Date: 24 February 2009
Our Ref: bmbc240209.jh
Job Ref: 15/822

**Erection of First Floor Side Extension to Oaks Building at Kendray
Hospital, Doncaster Road, Barnsley S70 3RD**
For Barnsley NHS Primary Care Trust

TITLE
KENDRAY - OAKS BUILDING
PROPOSED ELEVATIONS

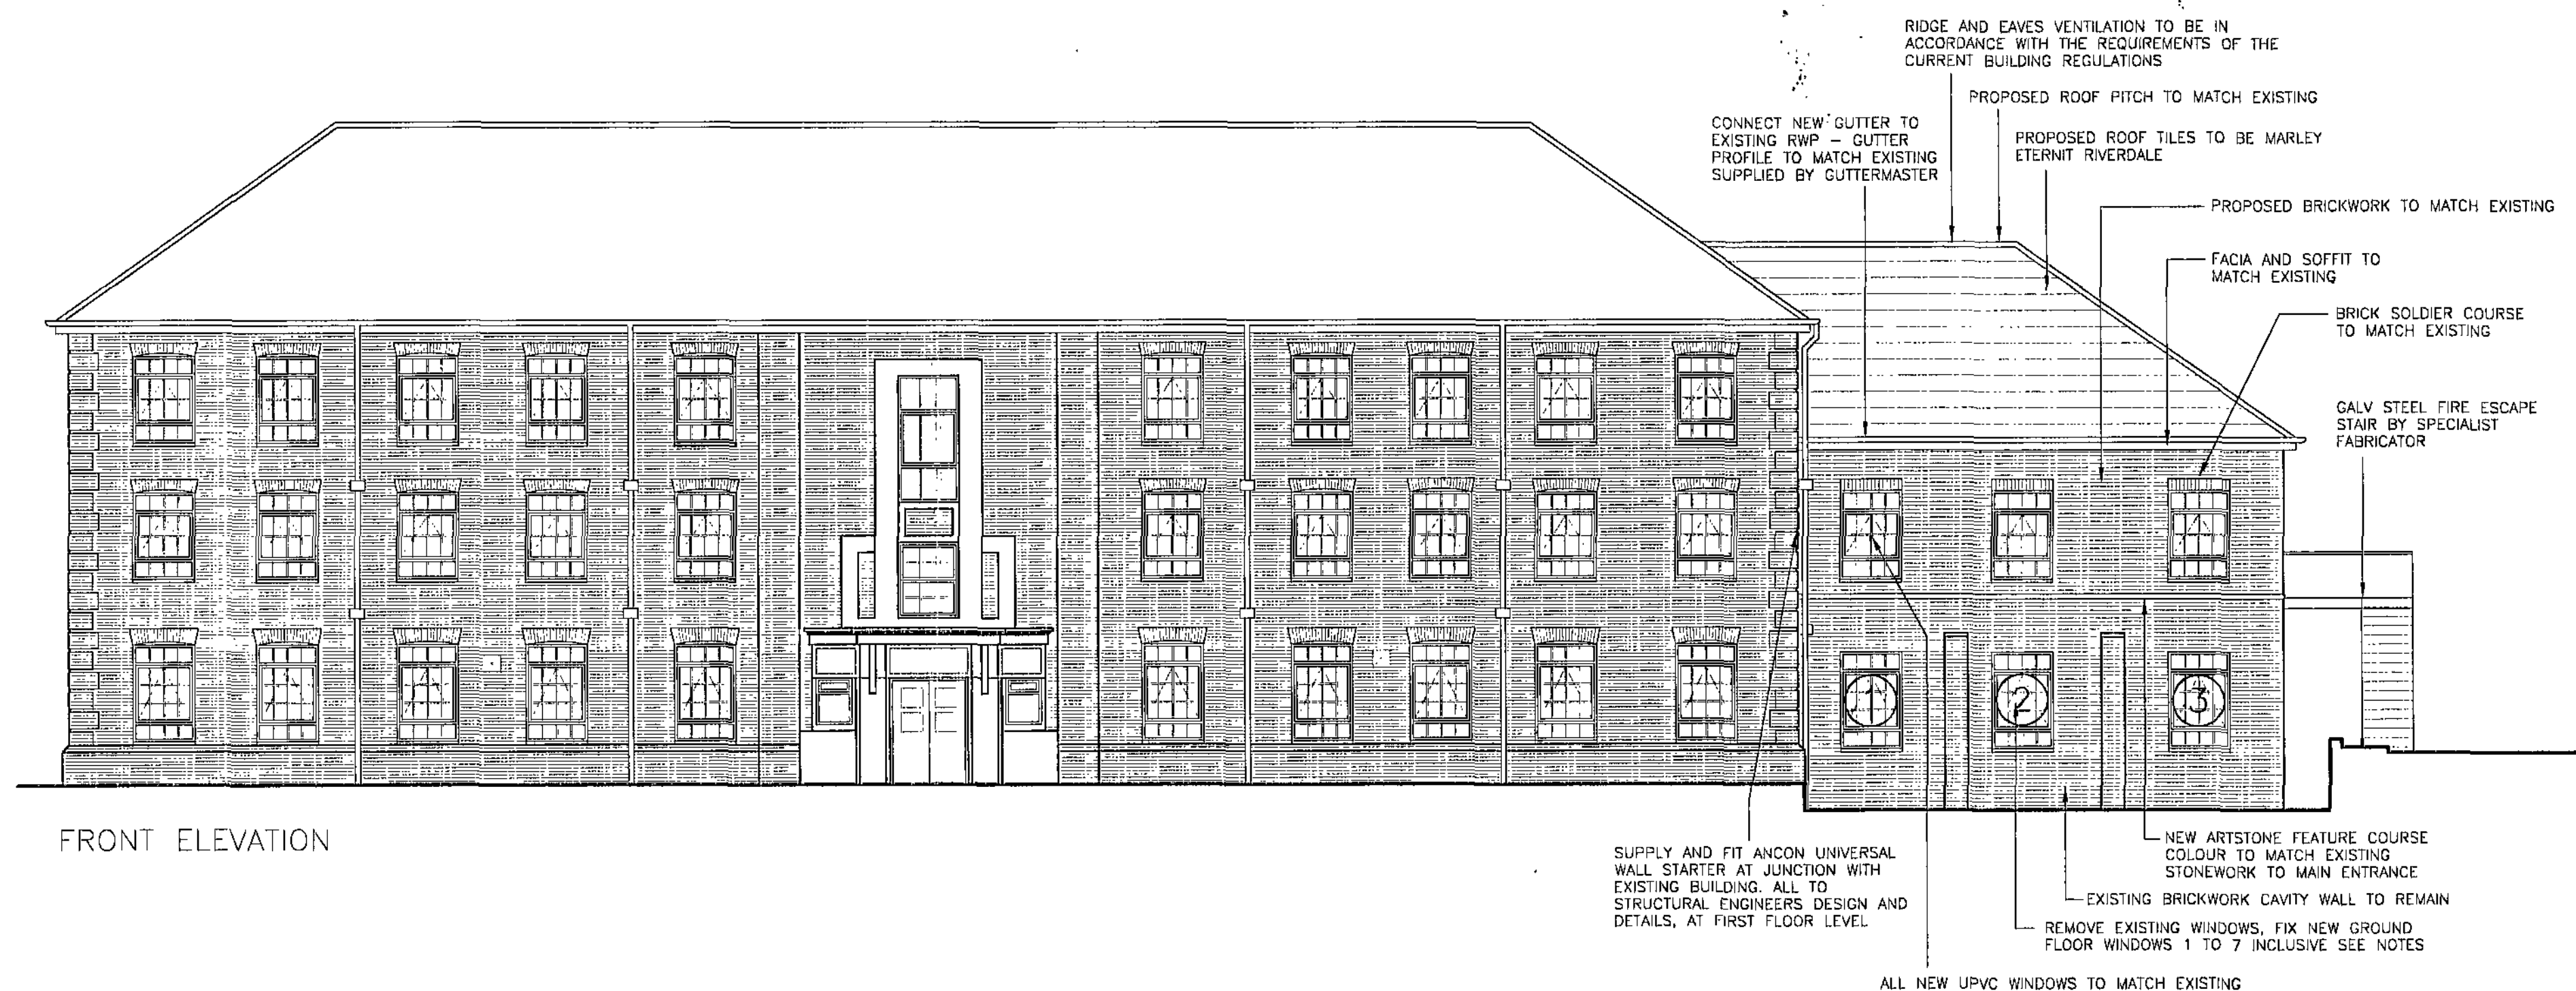
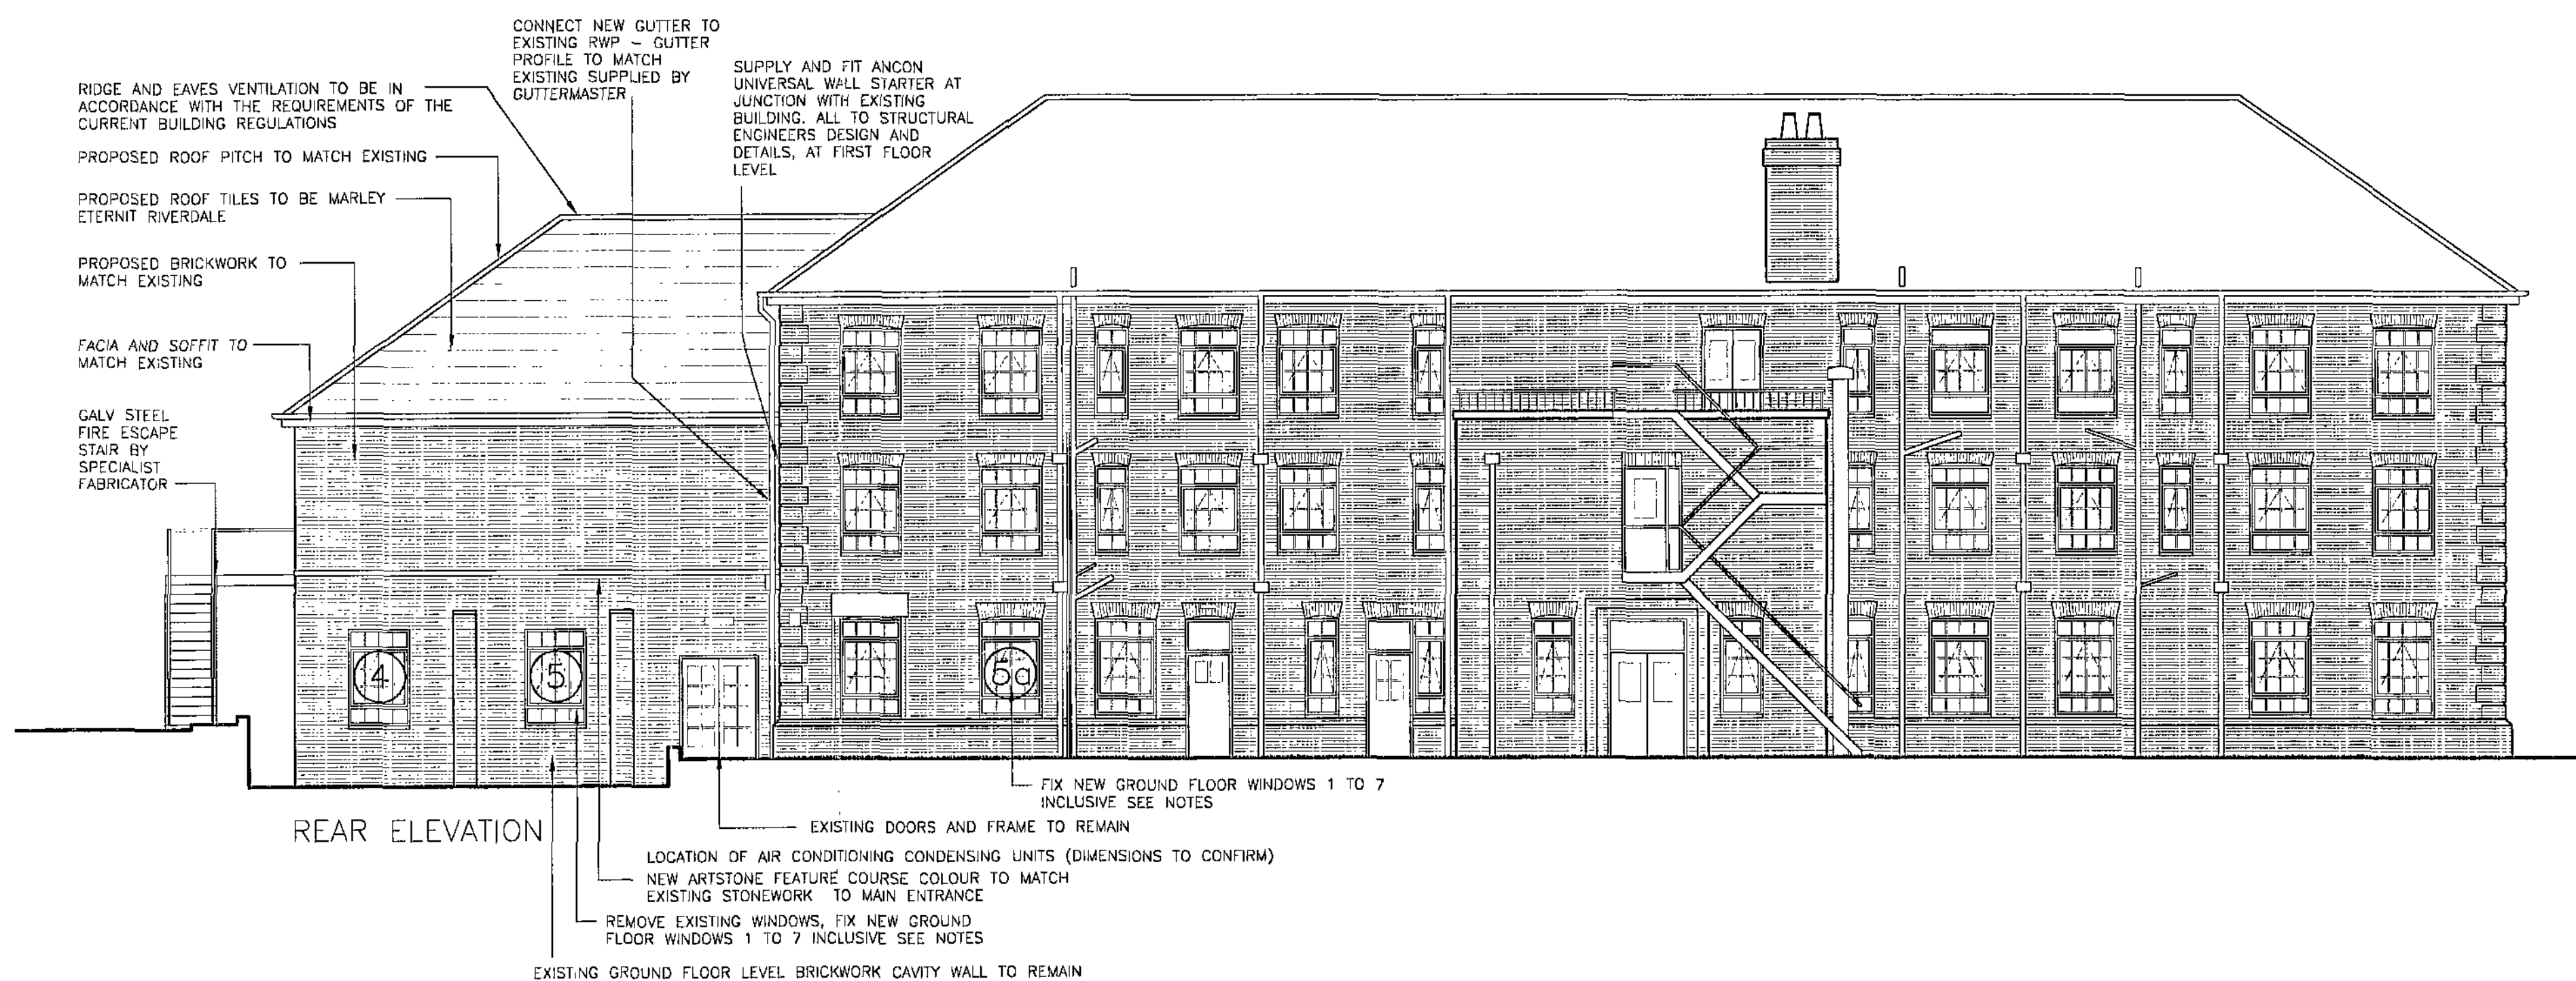
Following our telephone conversation today please find enclosed 2 No. copies of the amended floor plans and elevation drawings for the above project. As discussed, our Client wishes to carry out an internal alteration within the existing building at Ground Floor level, forming 3 No. offices ref: G-08A, G-09 & G-10, with office G-09 requiring the formation of a new window on the rear elevation, ref: 5a, on JTP elevation drawing.
